DELEGATED DECISION TO DETERMINE PLANNING APPLICATIONS

Reference No:	2024/62/90834/W
Site Address:	47, Thorpe Green Drive, Golcar, Huddersfield, HD7 4QS
Description:	Erection of two storey side and single storey rear extension
Recommending Officer:	Molly Storer

DECISION – CONDITIONAL FULL PERMISSION

PROPOSED GROUND FLOOR PLAN Scale 1:50

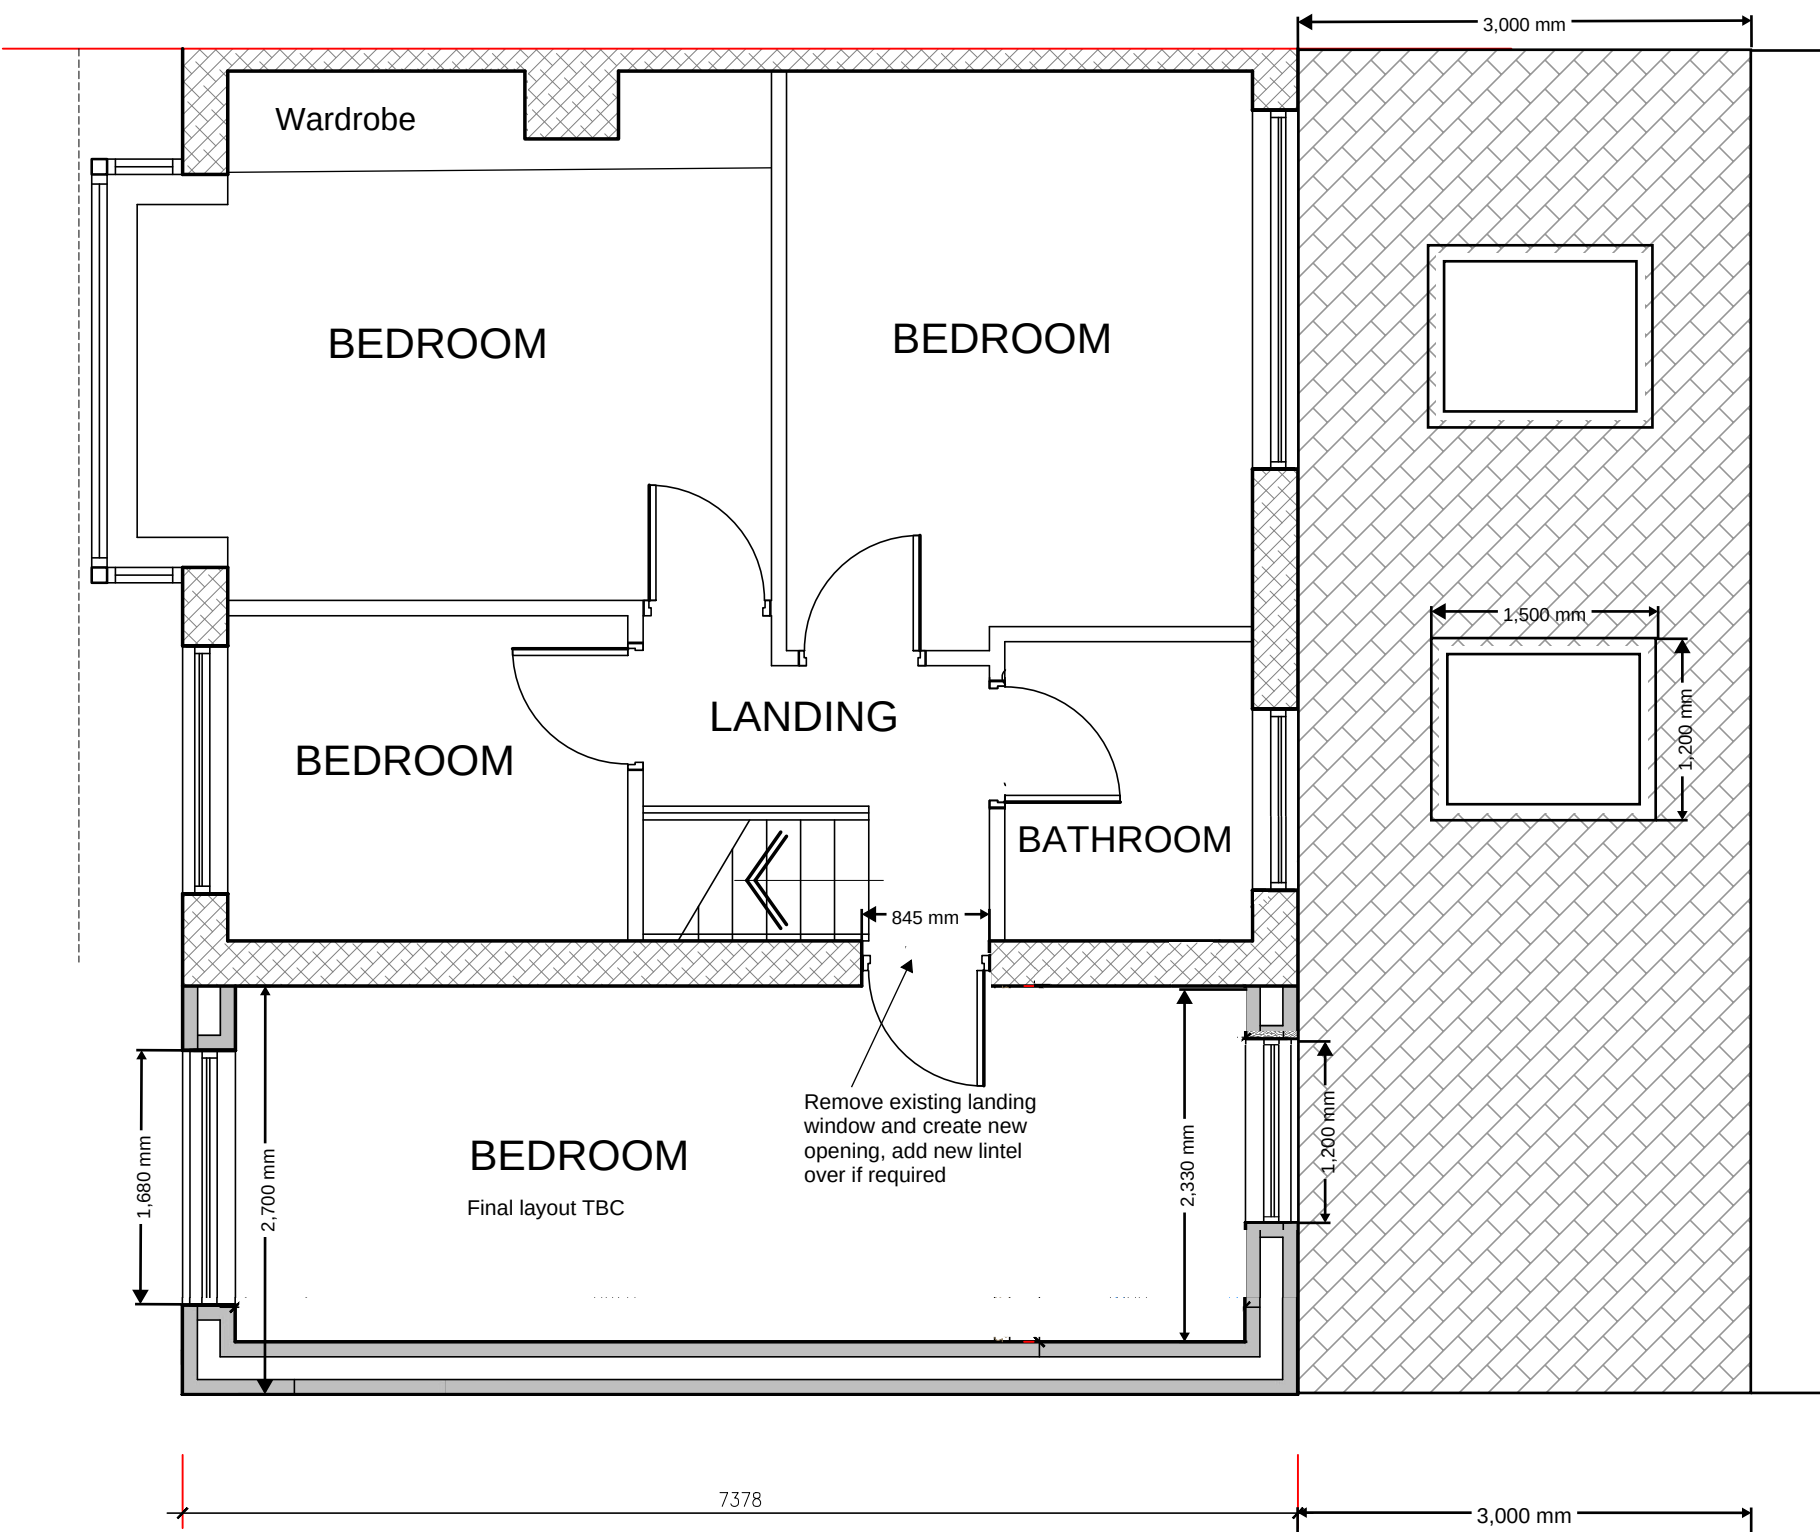
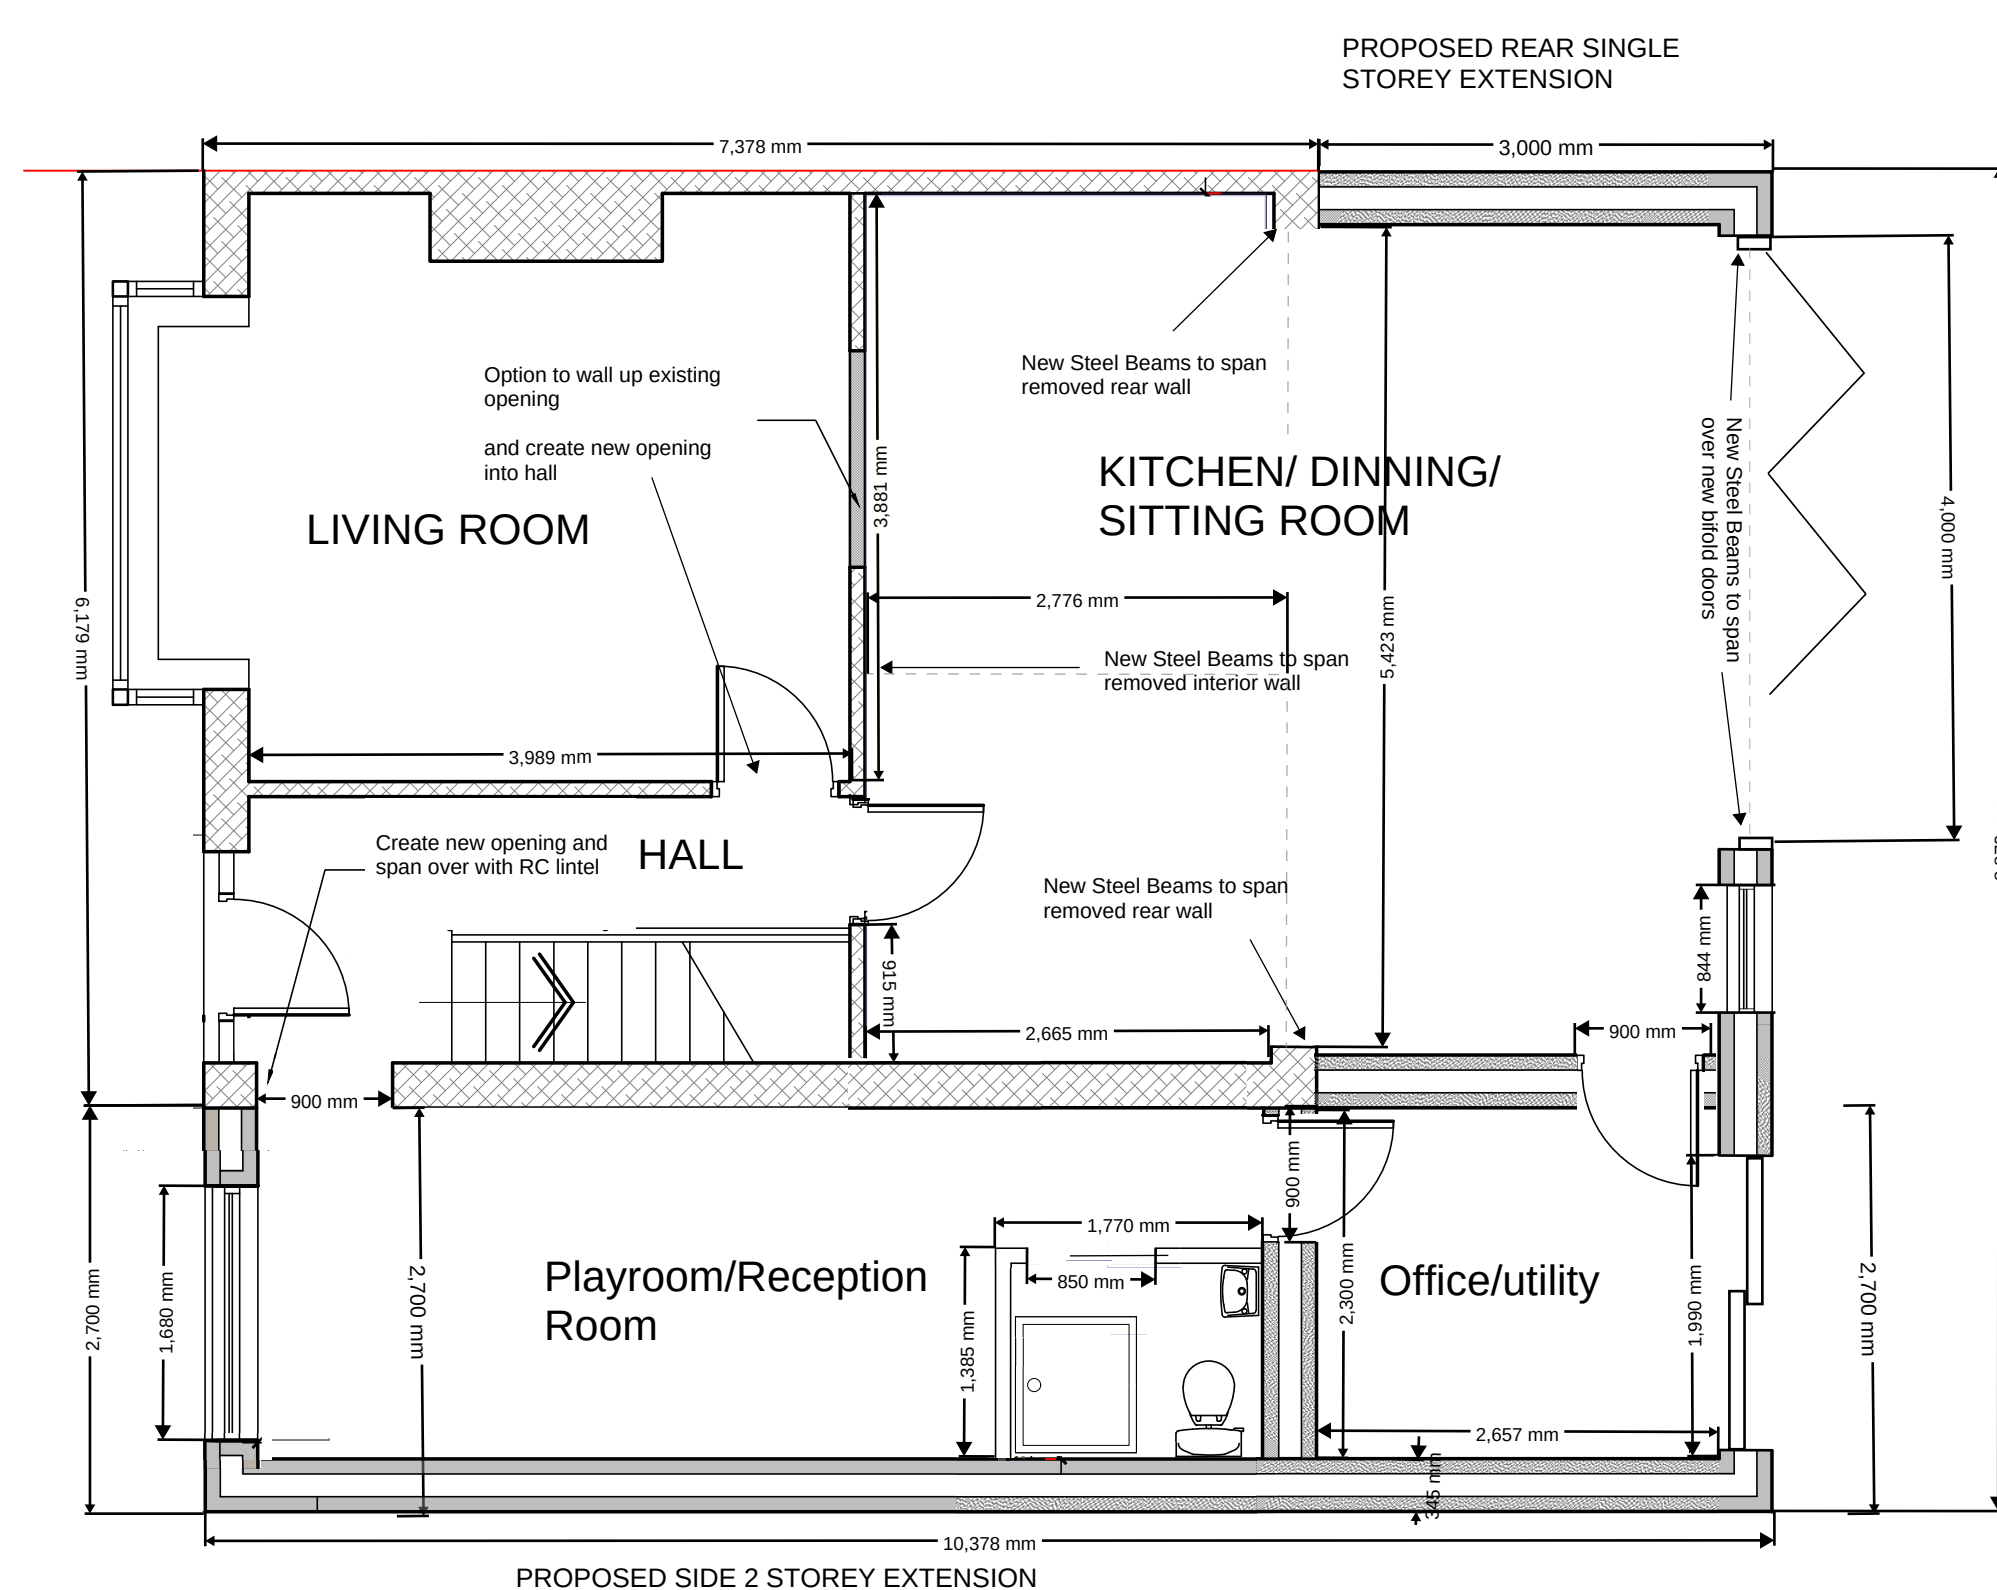
It was suggested that consideration should be given to setting back the extension from the front elevation of the original dwelling in order to comply with the SPD. The applicant was also informed of the SPD's 'comply or justify' policy whereby if a scheme departs from the SPD there is an option to justify it.

The two storey side extension would not be set back by 0.5m nor maintain a gap of 1 metre between the side wall of the side extension and the shared boundary as required by the SPD. However, the design would result in the side extension having a ridge line to match the existing and would lie in flush with the front elevation creating a visually harmonious appearance. Furthermore, as the applicant pointed out in justification of the scheme a number of properties within the immediate area have a similarly designed extensions incorporating two storey side extensions with flush roof lines and front elevations. Most noticeably No.55 and No.59 where the two storey side extension is also built up to the site boundary. As such, the extension would be in keeping with other extensions already constructed in terms of design and would respect the character and appearance of the area.

In this case the applicant was contacted to ensure that there was sufficient off-street parking available on site for the additional bedroom. The extensions would result in a 3 bedroom property. As such the SPD requires 3 off-street parking spaces to be provided. Plans were submitted which showed three off street parking spaces within the front garden. These shall be conditioned to be permeably surfaced in accordance with KDP 14 of the SPD and to provide sufficient parking in accordance with KDP 15.

The applicant chose to provide justification for the scheme which will be explored in the following report.

It is therefore considered that this element of the scheme is acceptable and would visually harmonise with the host dwelling and surrounding area. Whilst the proposed side extension does not strictly comply with the requirements of the SPD, due to its similarity to other property's within the surrounding area, the proposed works, in this isolated case, are considered acceptable within the remit of Key Design Principles 1 and 2 of the SPD.
